Our Ref: WA/22/22/DOC

Approval of details reserved by condition imposed under WA/22/15/OUT relating to conditions 12- surface water drainage scheme and 20 d)-details of forecourt layout, drainage and lighting.

Global Technologies Racing Ltd Arundel Road Fontwell BN18 0SB

Arun District Council have decided to **APPROVE IN PART details reserved by condition**

2.1.1 Floor plan

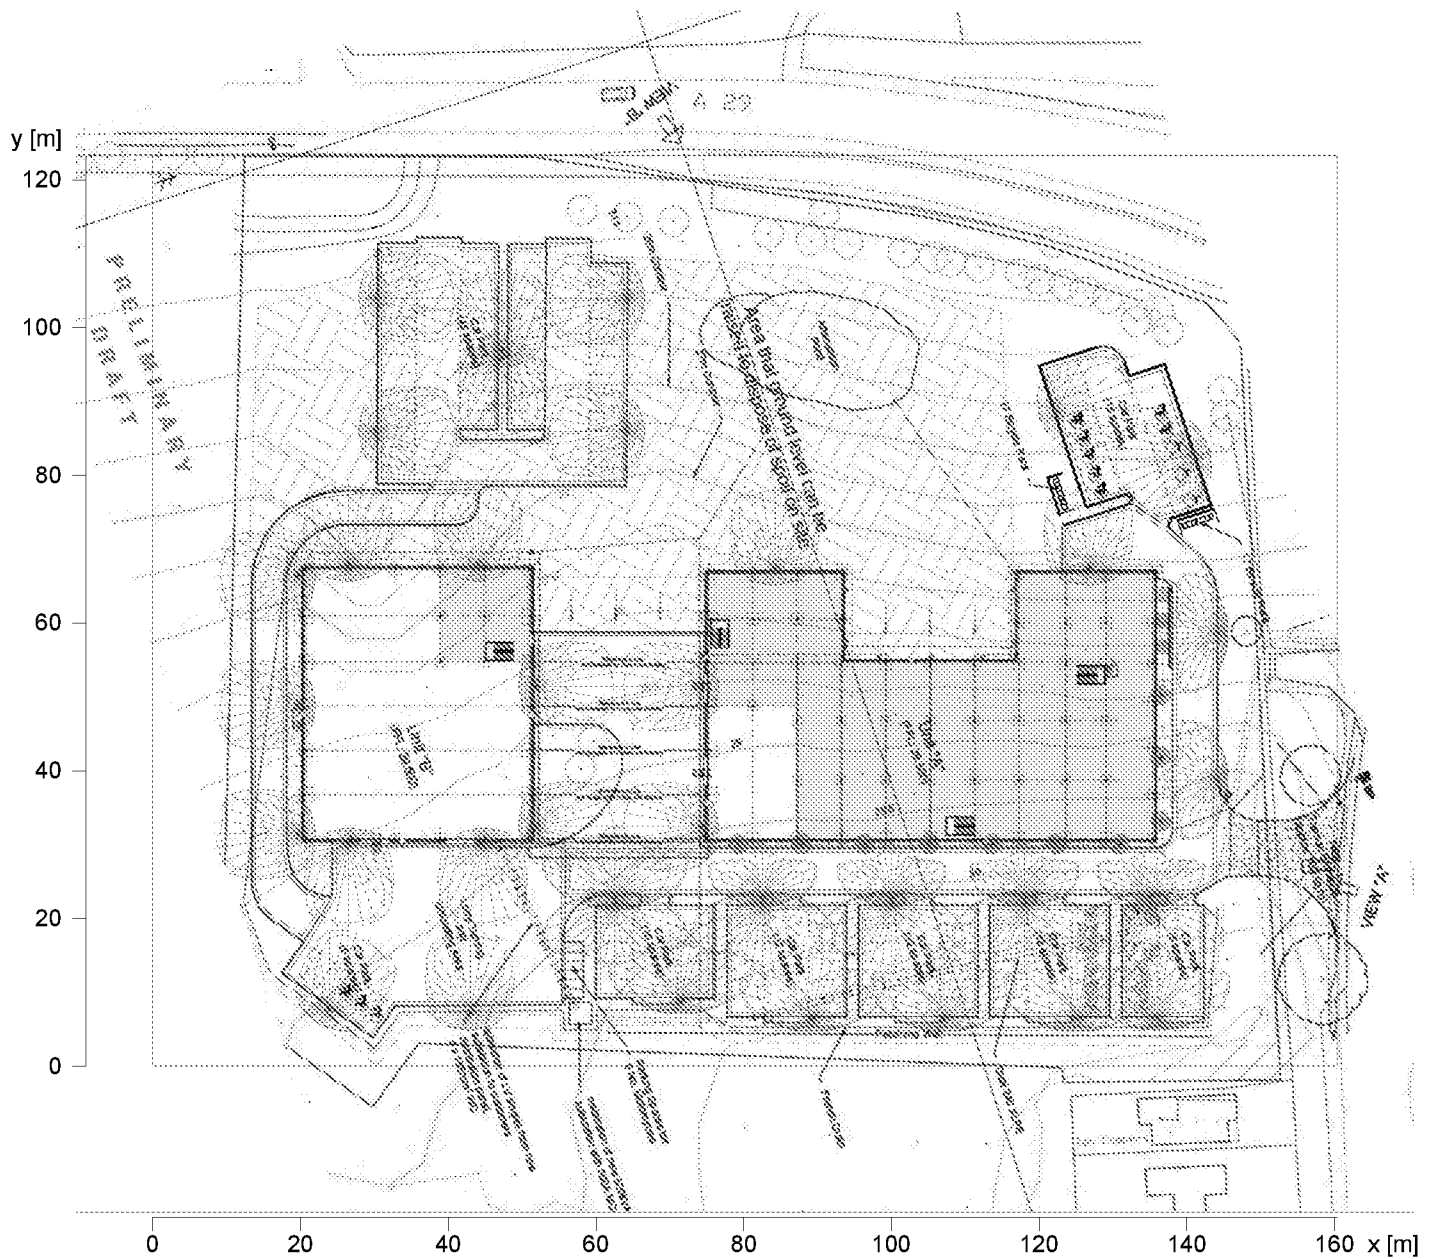
However, whilst lighting details were provided in support of the discharge of this condition and the proposed light fittings are acceptable. Appropriate detail to confirm the location and siting of the individual light fittings and details of their control and timing have not been provided. Therefore, this detail should be provided to fully discharge Condition 20(d).
